CITY OF ALBUQUERQUE

RE: EL RANCHO GRANDE, UNIT 8A (M-09/D019B)
Engineers Certification for Release of Financial Guaranty
Engineers Stamp dated 08/06/2003
Engineers Certification dated 09/20/2004

Re: De Anza El Rancho 8A
Construction of Box Culvert at Gibson and Snow Vista Channel
CERTIFICATION OF COMPLETION AND ACCEPTANCE

Re: El Rancho Grande 8A
AMAFCA Field Visit

CONCRETE RUNDOWN SECTION B-B

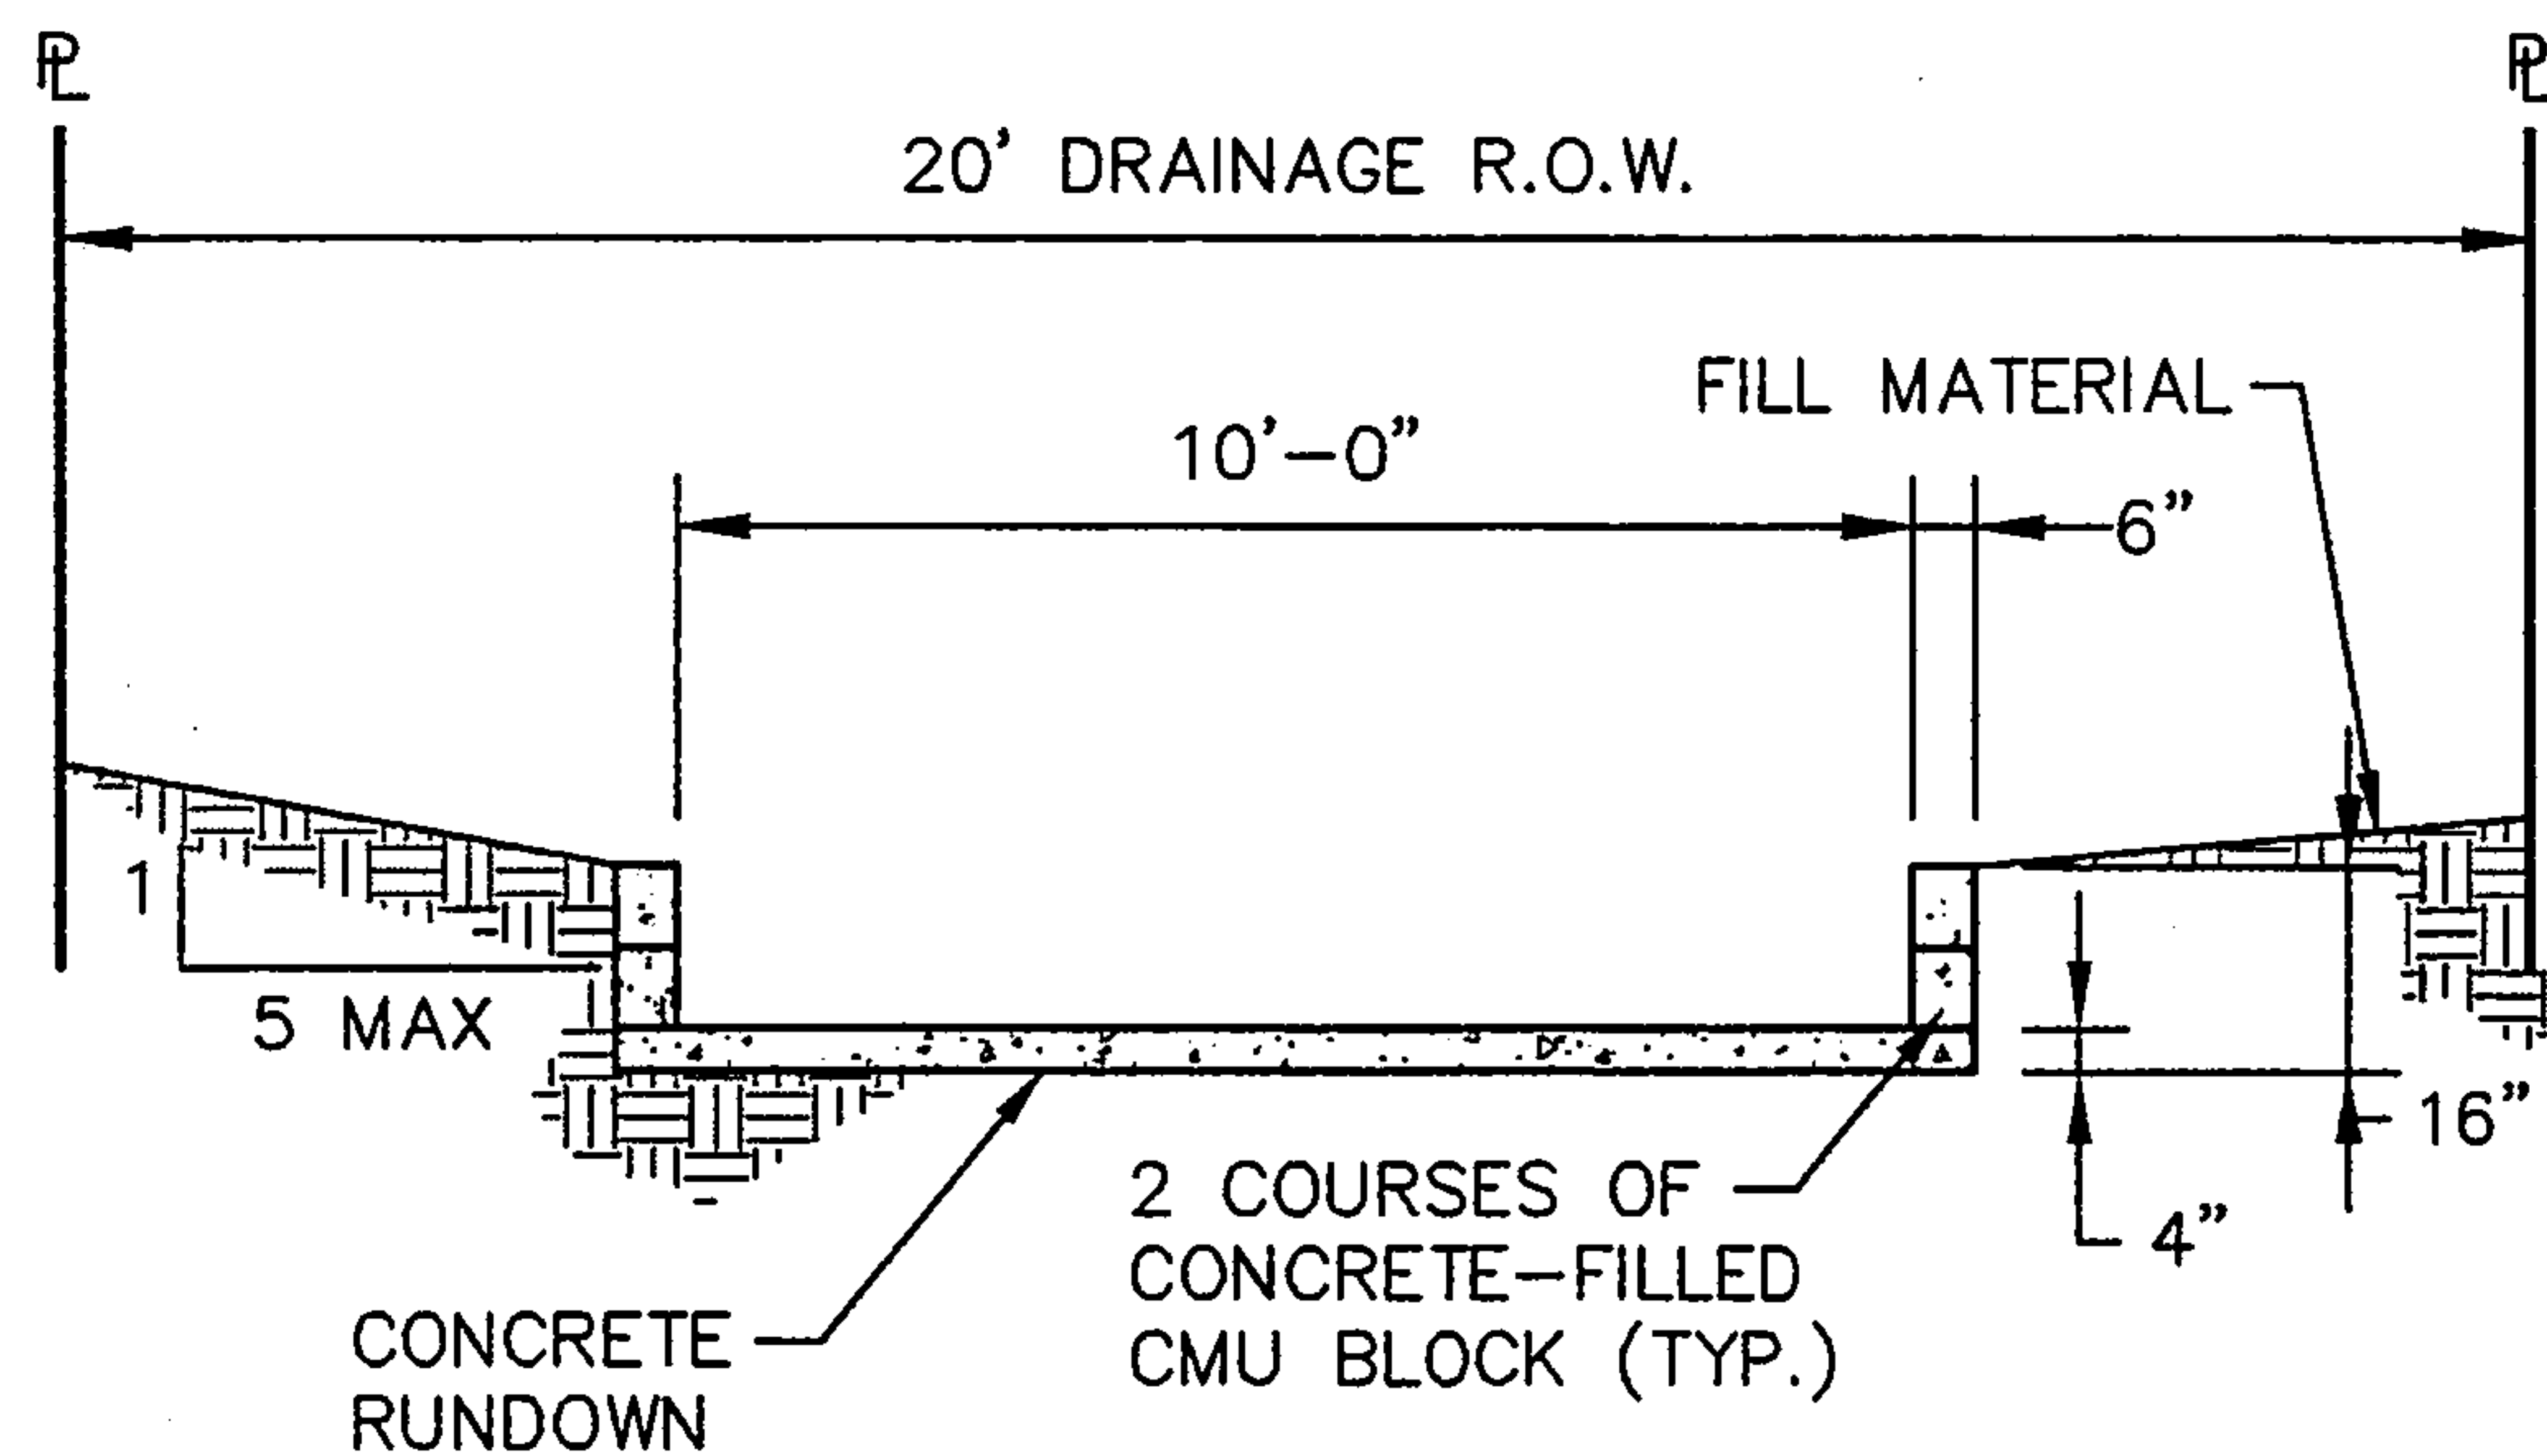
1. Rundown at the east end of De Anza Drive has been undermined and destroyed.
 - a. Concrete section undermined
 - b. Riprap section from the concrete section into the Snow Vista channel as been destroyed due to excessive undermining.

Please review the design of the rundown to ensure that design was adequate for the location, soil conditions and flows anticipated.

Please submit to AMAFCA, by January 11, 2005, a letter report detailing the cause of the damage to the rundown, verification that the design of the rundown is adequate and a work plan to remediate the rundown
